**Hinckley & Bosworth Borough Council**  
**Interested Party Reference Number: 20039546**

**Deadline 4 Submission:**

**Response to Deadline 3 Submissions:**

**Application by Tritax Symmetry (Hinckley) Limited for an Order Granting  
Development Consent for the Hinckley National Rail Freight Interchange**

Note: To be read in conjunction with the Access and Rights of Way Plans (document reference: APP-017 to APP-020) and the Public Right of Way Appraisal and Strategy (document reference: 6.2.11.2)

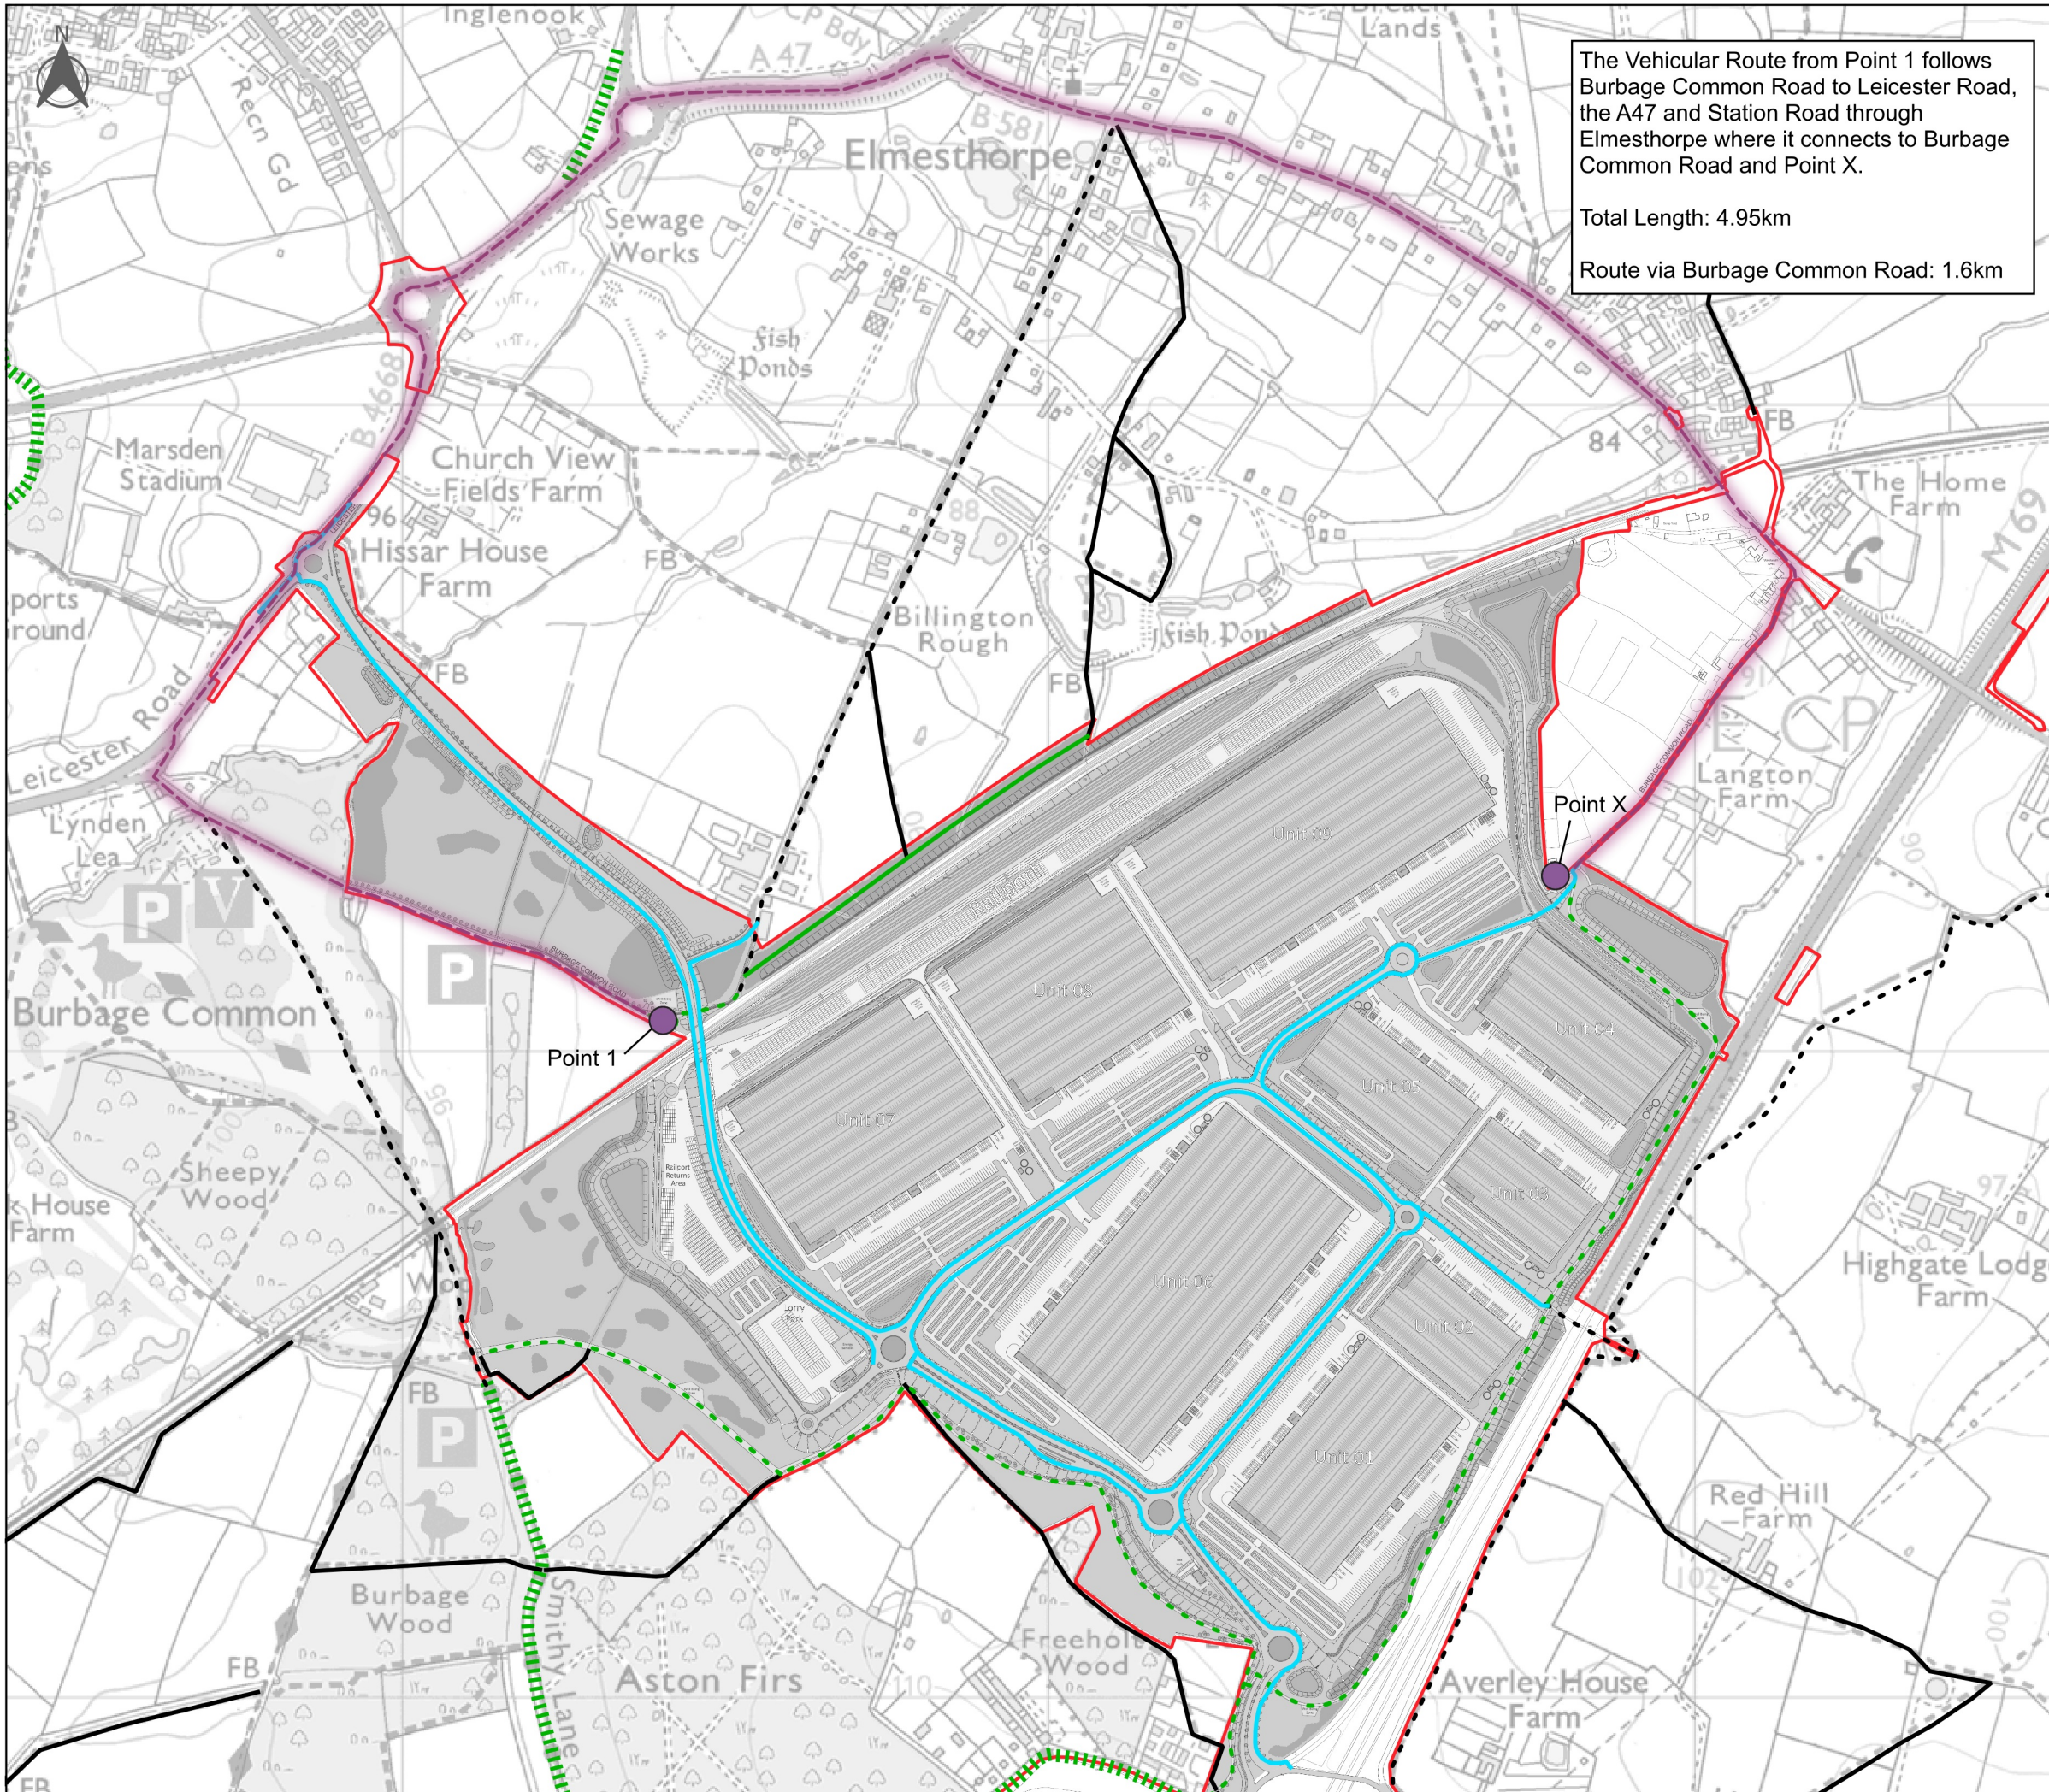
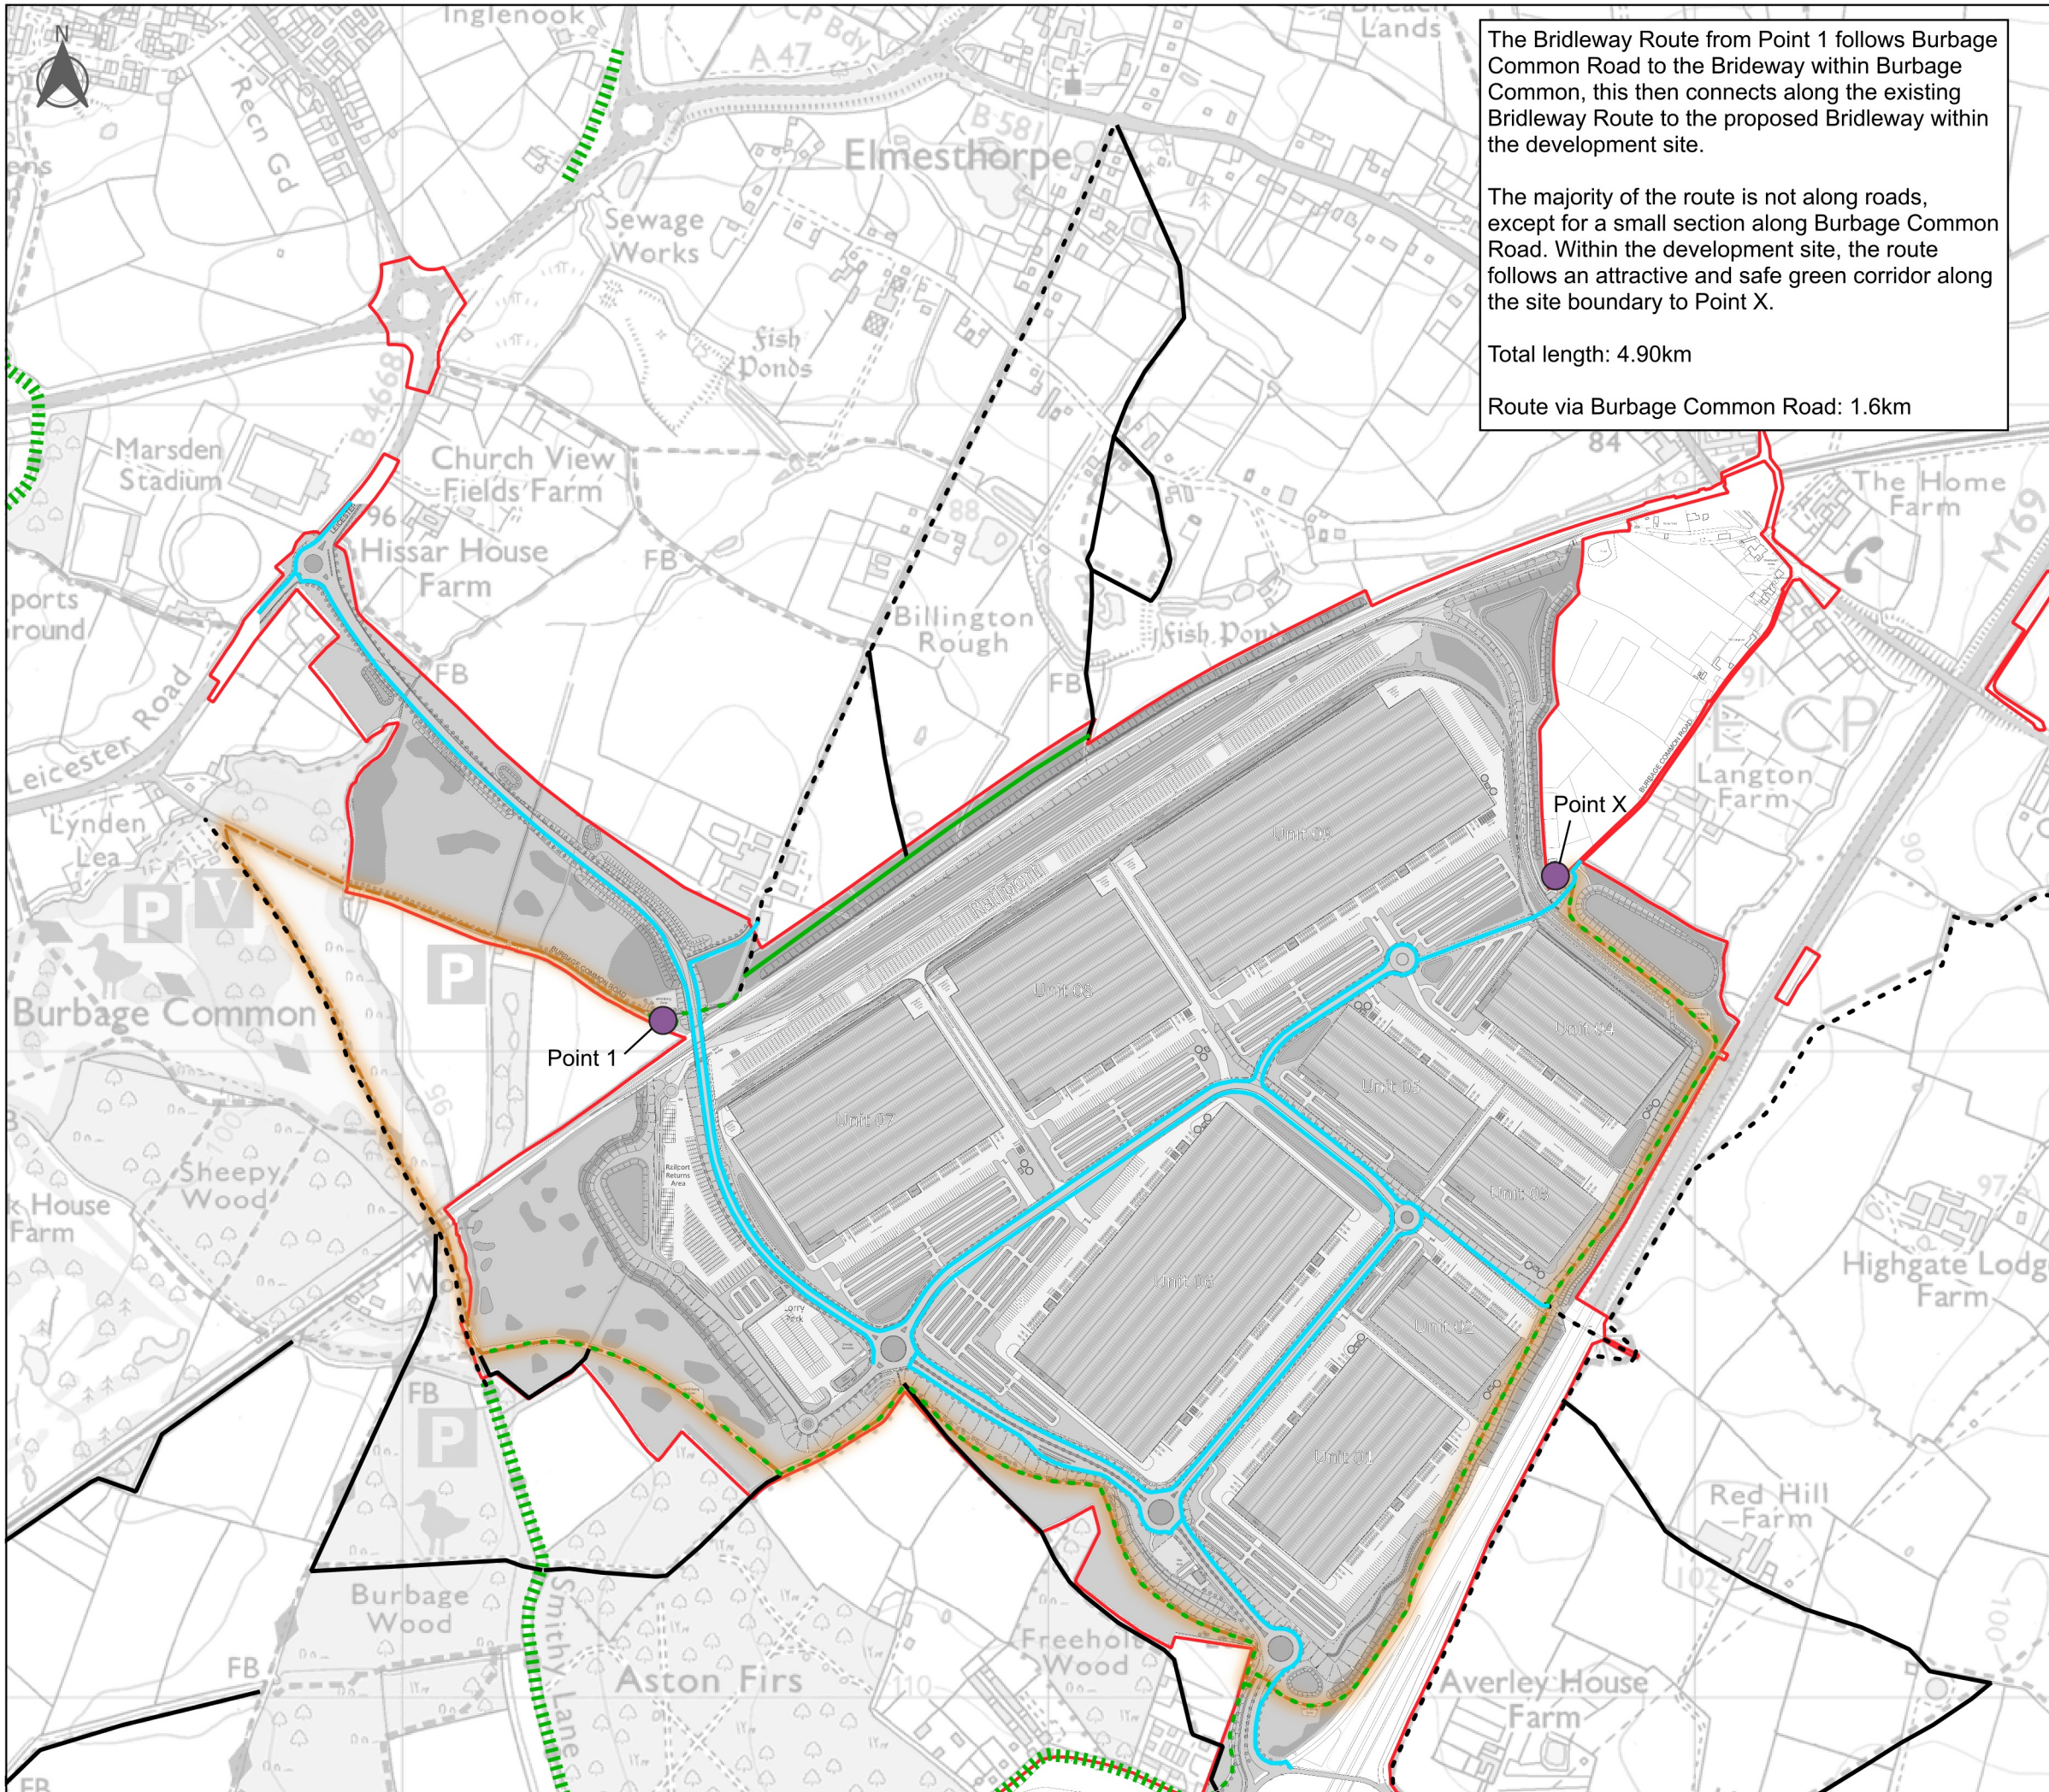
<b>REP3 – 054 – Accessibility Plans for Burbage Common Road</b>	The accessibility plans for walking and cycling appear incorrect and thus confusing. For example they show a ‘proposed permissive path’ for walkers and cyclists along the A47 – but the Council would expect these to be part of the publicly adopted highway and thus, not permissive paths. The council has expressed concern at details of these routes including the

need to cross the link road in path continuity and how safe and what quality the permissive paths will be across the site as well as crossing facilities - these concerns remain.
<b>REP3 – 018 – Framework Travel Plan</b>	
Page 21	There are some anomalies which require correction between the description of existing bus services in the sustainable transport strategy and the Travel plan, such as the service 8
Page 28	<p>It is not clear which of the elements listed here from the Sustainable Transport Strategy (STS) will be implemented by the applicant and when; and what in what detail (such as the cycling improvements). As noted in the separate comments in relation to the STS, the bus proposals appear minimal with no detail of the catchments, journey and walking times relating to the proposals. The Travel Plan only appears to commit to the X6 service, an extension of the 8 service and relatively unspecified DRT provision. These elements need to be further described and detailed to be meaningful measures in the Travel Plan that can be secured and monitored.</p> <p>As one example, in respect of bus service 8 (Hinckley Nuneaton), table 6 in the STS describes a potential option; there is no plan of the proposed route and stops, the stop catchments and service journey time, including walk to/from bus stops ( or interchange with described internal shuttle bus ) . It is not quite clear the timings of the service and days of week of operation although it seems to be a 1 per hour proposal. Without this information it is difficult to understand whether this service will provide good accessibility and how it can be secured.</p>
